REF :- PROPOSED RETENTION OF UNAUTHORISED REPLACEMENT OF TIMBER STORE

LAND OPPOSITE ORCHARD HOUSE, BACK LANE , GRINDLETON

(APP NO 3/2022/0921)

West Elevation
1:50 Scale
Replacement Timber Store - As Built

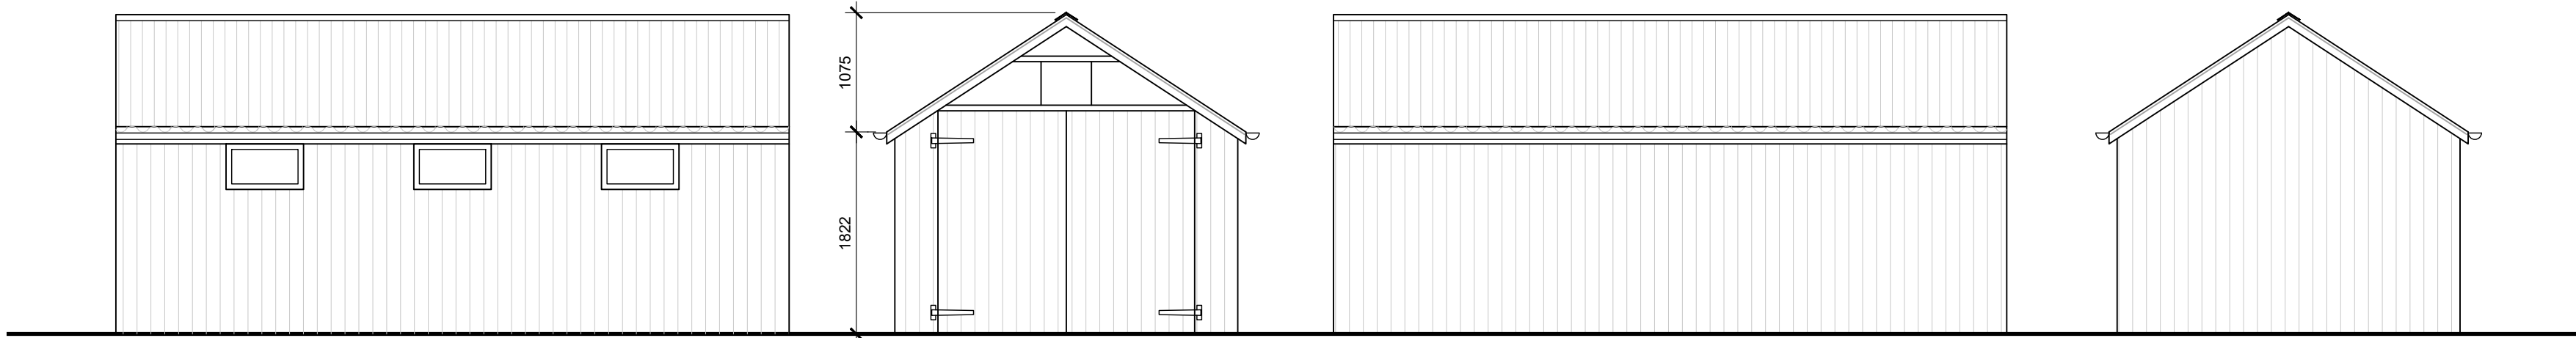
The recently erected building is in the form of a stable block giving the impression of equine use to third party onlookers which is more akin and acceptable to land use.

In fact is for additional storage space of commercial tools and domestic paraphernalia in support of the existing building.

The building stable doors have been blanked out with full panels to suit the proposed description more akin to a store,

West Elevation
1:50 Scale
Existing Timber Store - To Remain

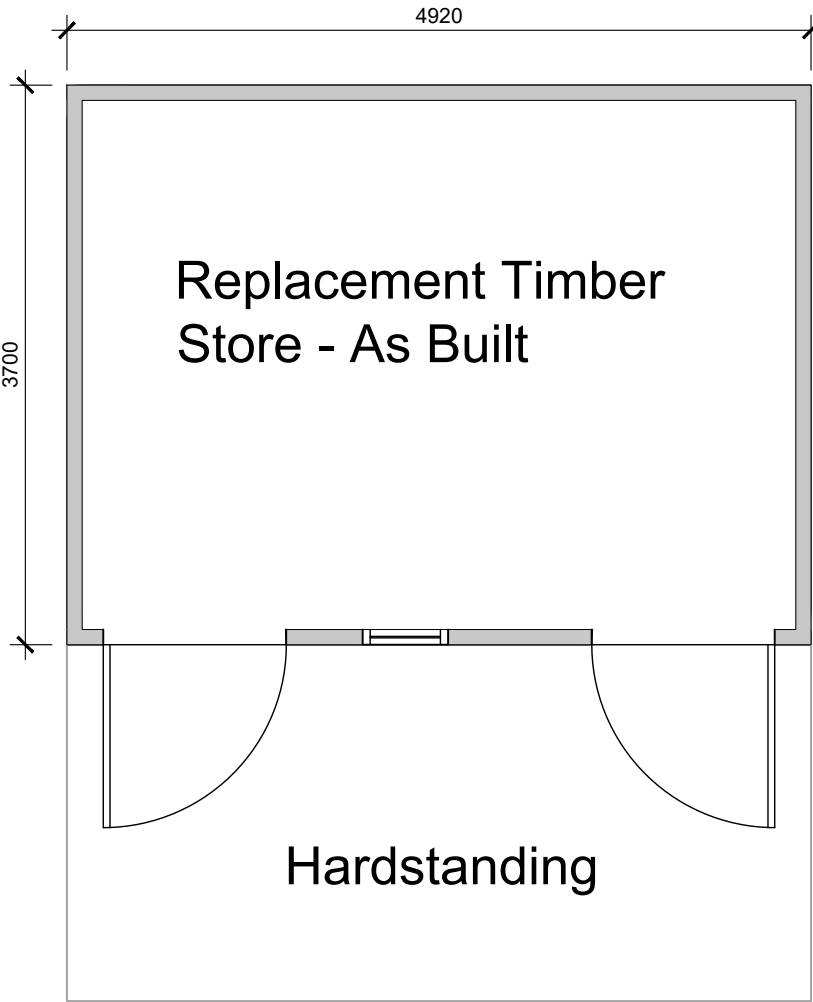
If the application is allowed emphasis should be made to its replacement of the existing as a planning condition ( the existing building should be demolished)
